HUITT-ZOLLARS

Address Circle Phase I

RE: Addison Circle Phase I Public Infrastructure
HZI Project No. 01-2013-02

RE: Addison Circle Phase I Public Infrastructure
HZI Project No. 01-2013-01

ADV-D1
(ITEM NO. 136)

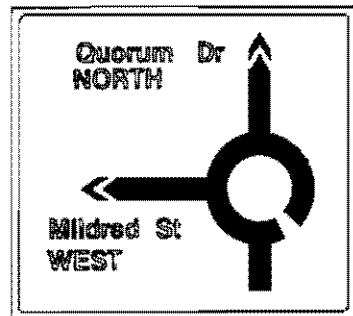
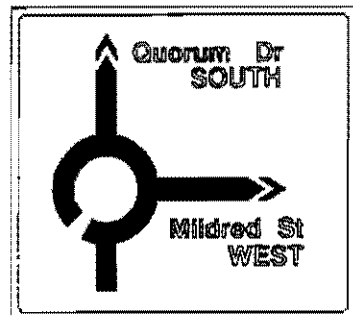
The Town of Addison has approved the name change of Mildred Street to Addison Circle. Please provide a change order price for field modifications to signs "ADV-D1", "ADV-D2" and ST-3. Each sign should be modified to read "Addison Circle" as noted on the following page.

Gibson & Associates is now authorized to proceed with the repair of roundabout sign (ADV-D1) for the change order amount of \$673.75 as stated in your letter on January 30, 1997.
